From: [REDACTED]
Sent: 24 April 2026 15:46
To: [REDACTED]
Subject: 51321/APP/2025/2991 - Haydon House, 296 Joel Street – Further Design Comments

Regarding comments on Haydon House, please see below for your consideration.

PROPOSED GROUND FLOOR PLAN

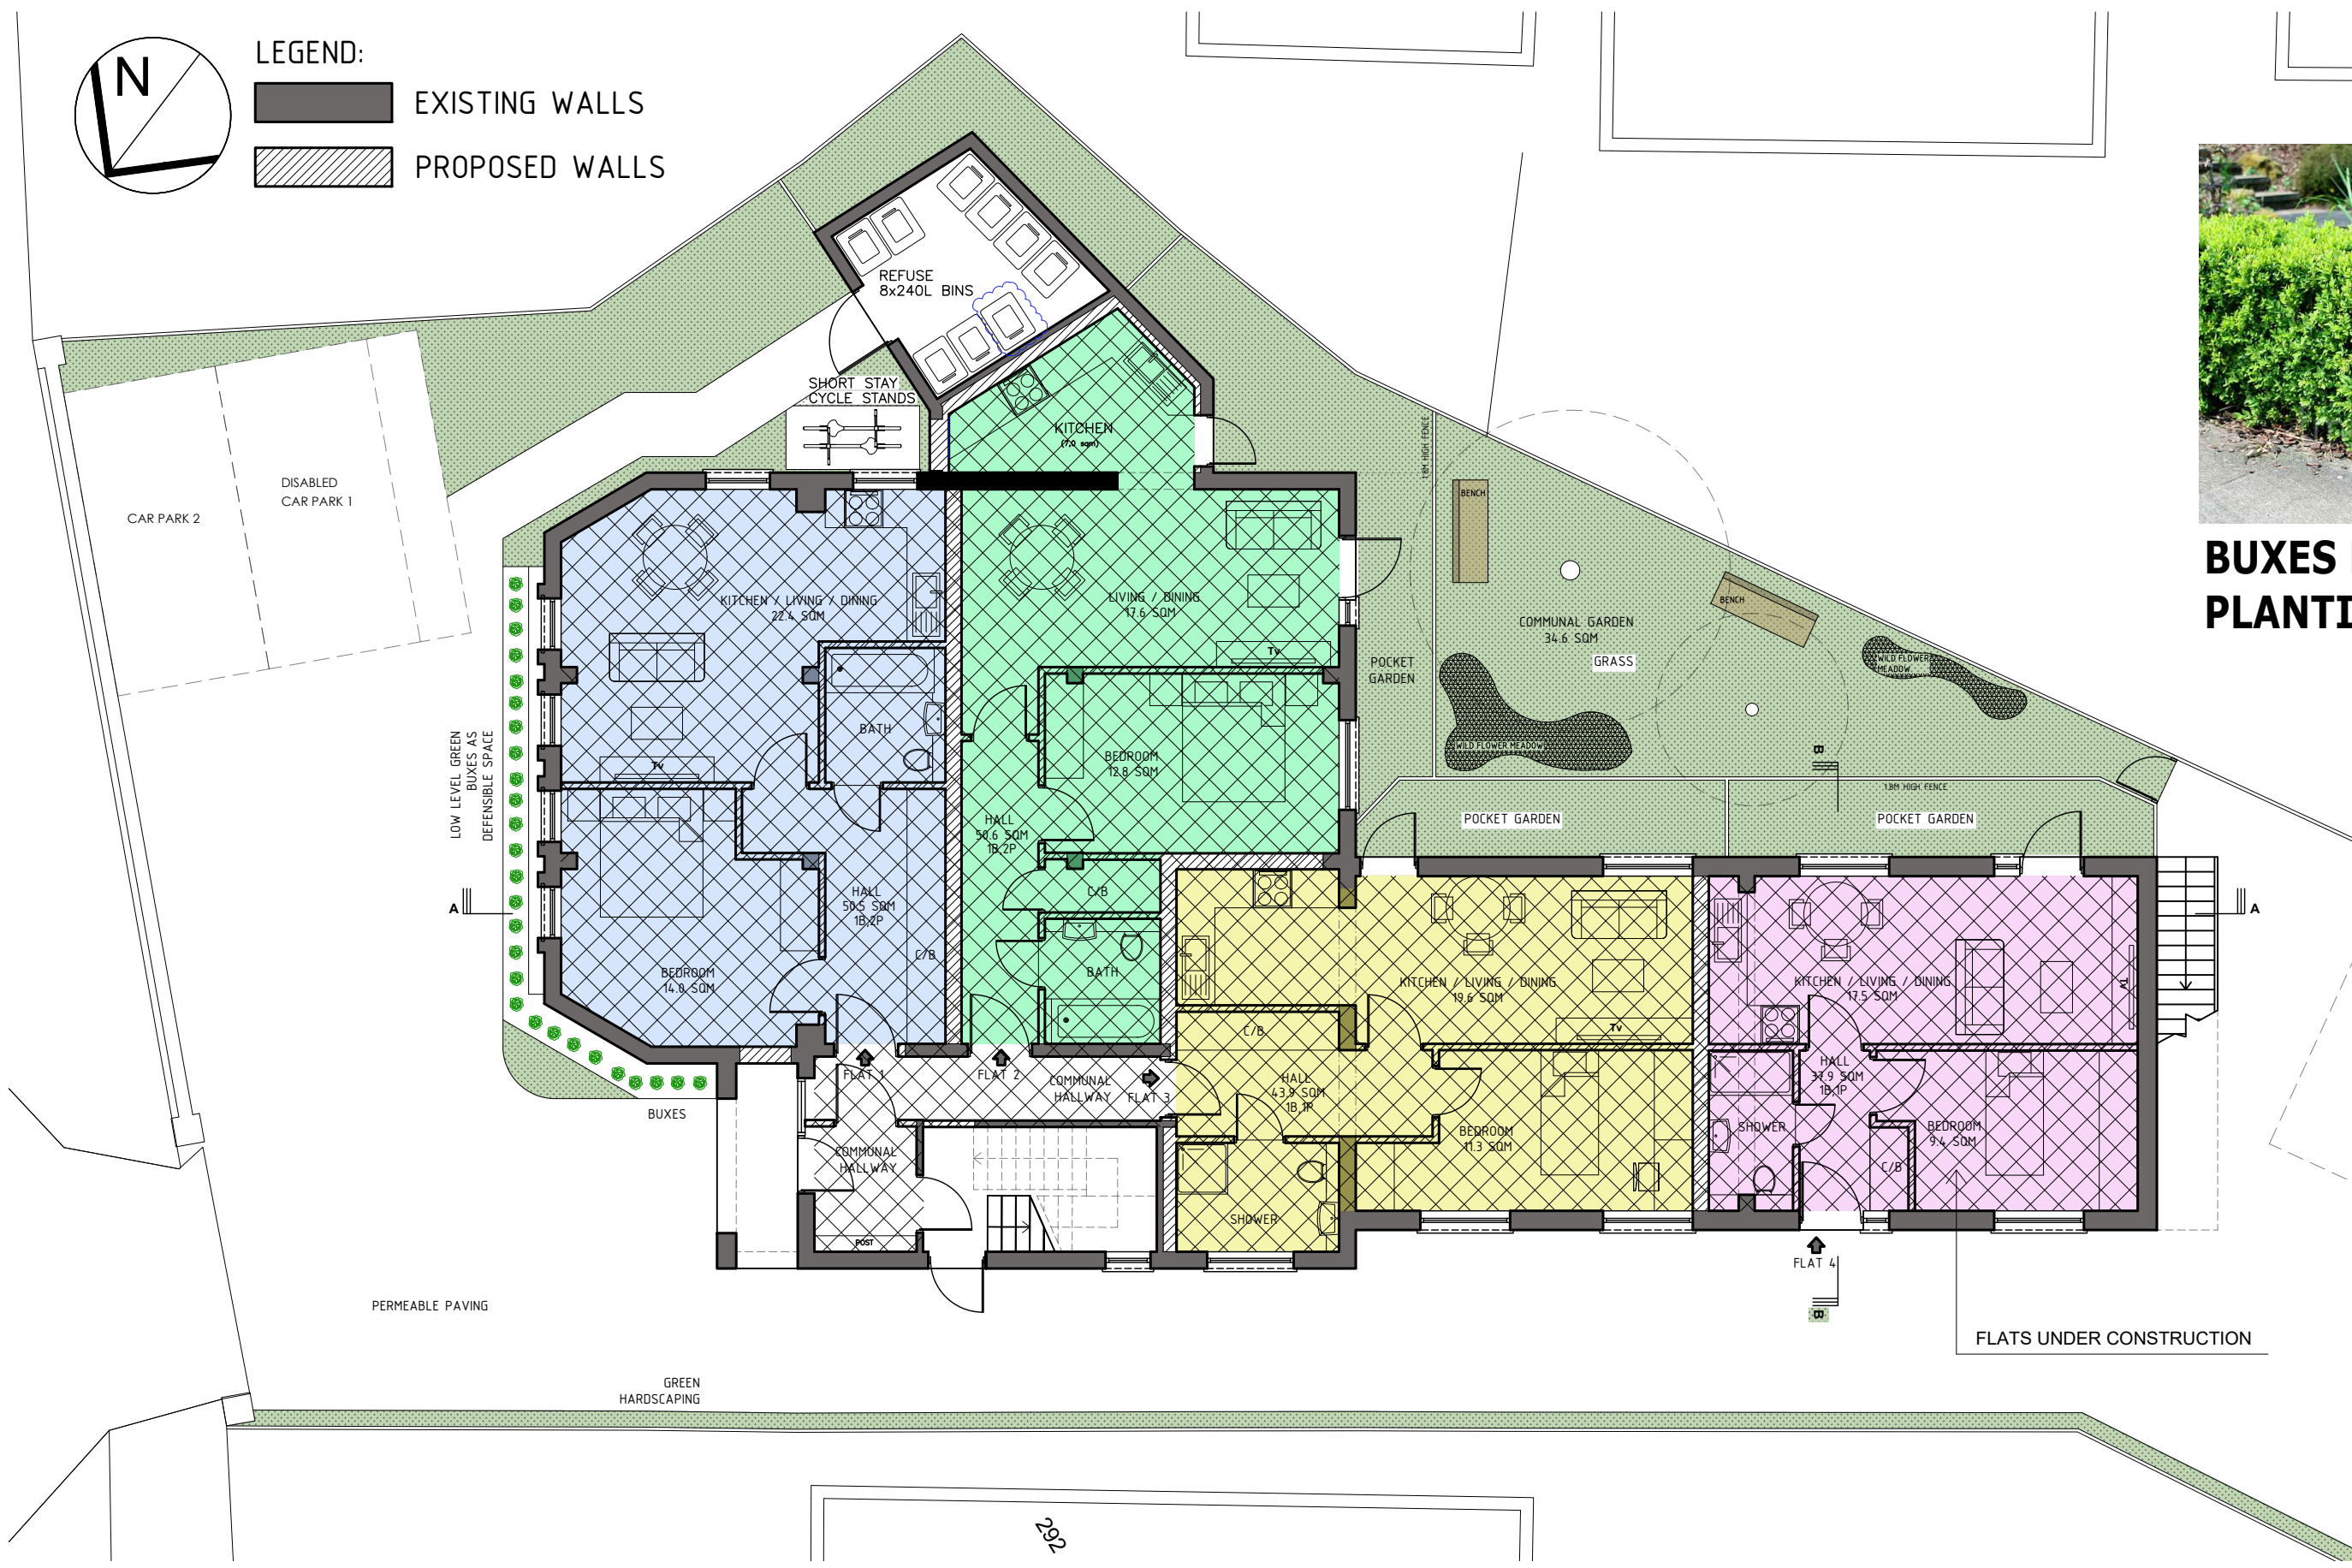
Provision of a family sized unit with no private amenity space.

The new unit will rely entirely on the existing rear communal garden. We highlighted this policy concern during the pre-application stage. It is at the planning officer's discretion whether the shortfall in private amenity space is acceptable when balanced against the need for a family-sized dwelling.

When weighing this balance, there are two factors which should be taken into account: the physical limitations of extending an existing property, and the fact that the garden is communal rather than allocated to specific units. We previously suggested that more substantial improvements to this space were needed to make it genuinely usable / meaningful / inviting for residents. The applicant has made some minor enhancements to the space.

PROPOSED FRONT ELEVATION

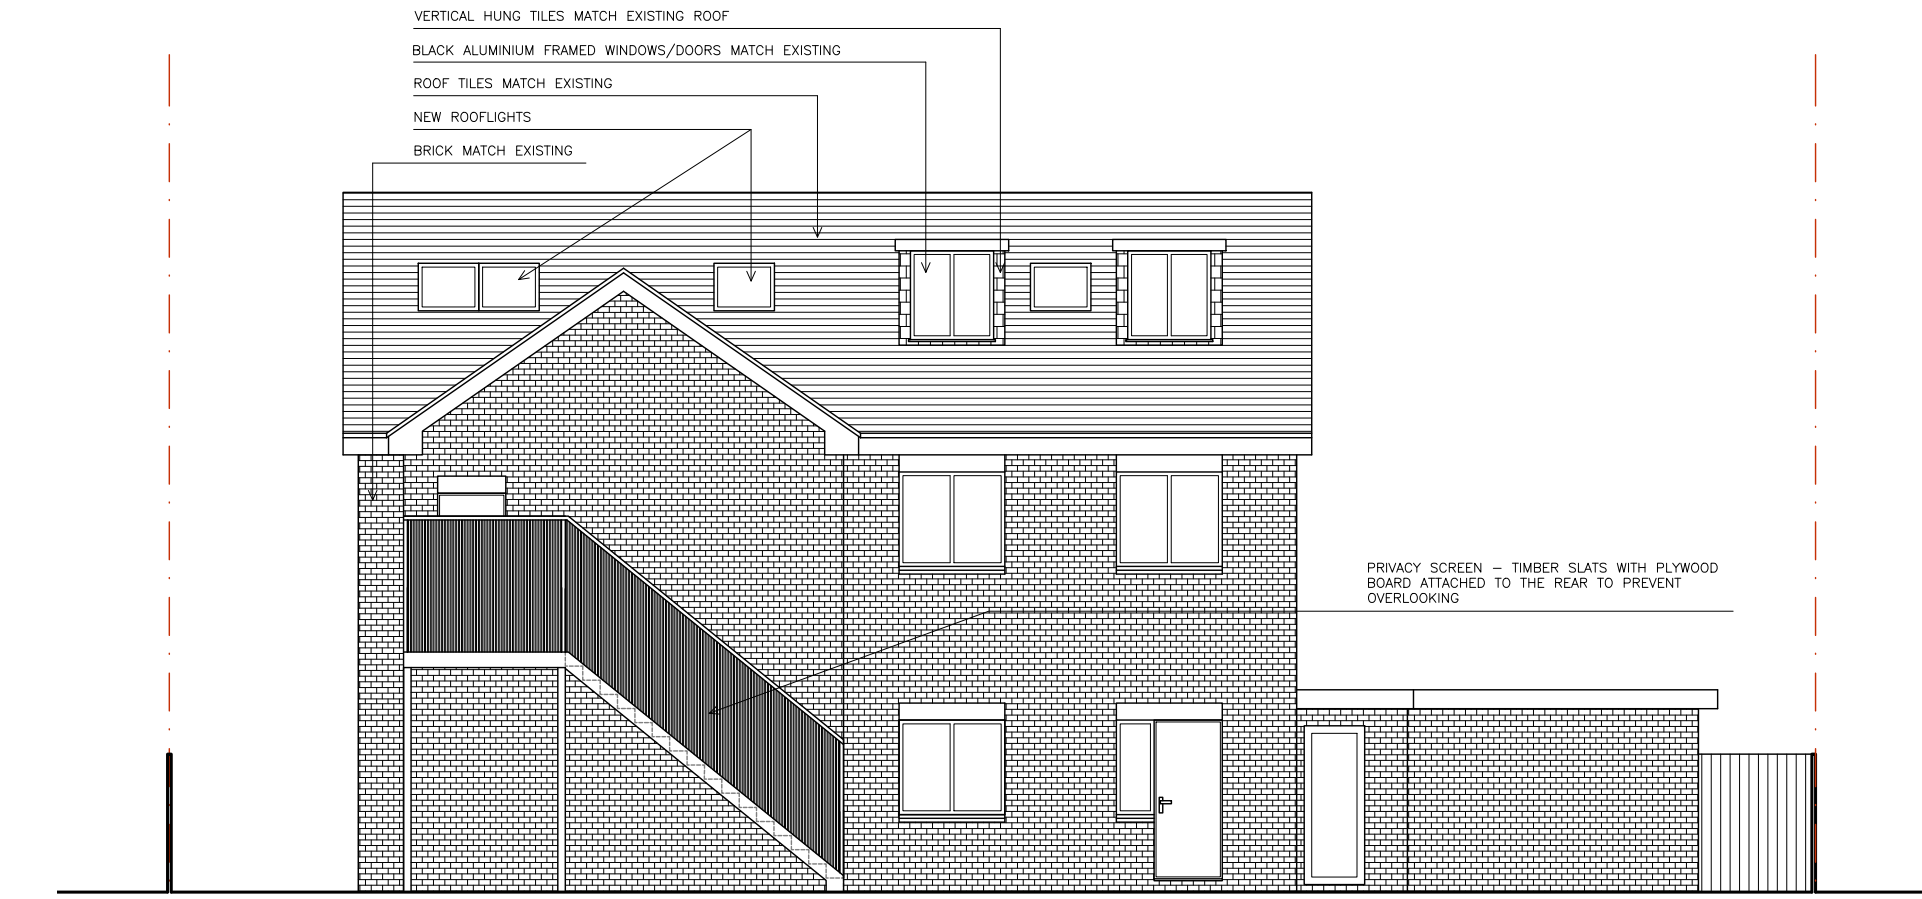
Scale of the front gable.

Although the gable front appears over-scaled in elevation, the chamfered corners will visually soften this effect in reality.

The tiled roof should effectively smooth the transition between the main gable pitch and the lower-pitched chamfered sides, further underplaying the prominence of the forward-projecting element.

Alternative designs, such as extending the gable to cover the chamfers, were explored but deemed more visually impactful and it was decided that the existing footprint's geometry necessitates a simple roofscape.

Furthermore, the chamfered section of Haydon House is comparable to 292 Joel Street, and the forward projection is contextualised by 31 Deerings Drive, which also steps forward at the end of the row.

Given the constraints of extending an existing building, we consider the projection and massing to be broadly acceptable. Any resulting visual impacts should be weighed in the planning balance against the benefit of providing a new family-sized dwelling in this location.

Potential privacy issues due to double height windows at the front.

To mitigate this, there is merit in introducing a spandrel panel. The lower portion of each window could incorporate frosted or opaque glass — either as an infill or glazed internally — to effectively resolve the privacy, internal comfort & useability concerns without significant impacts externally.
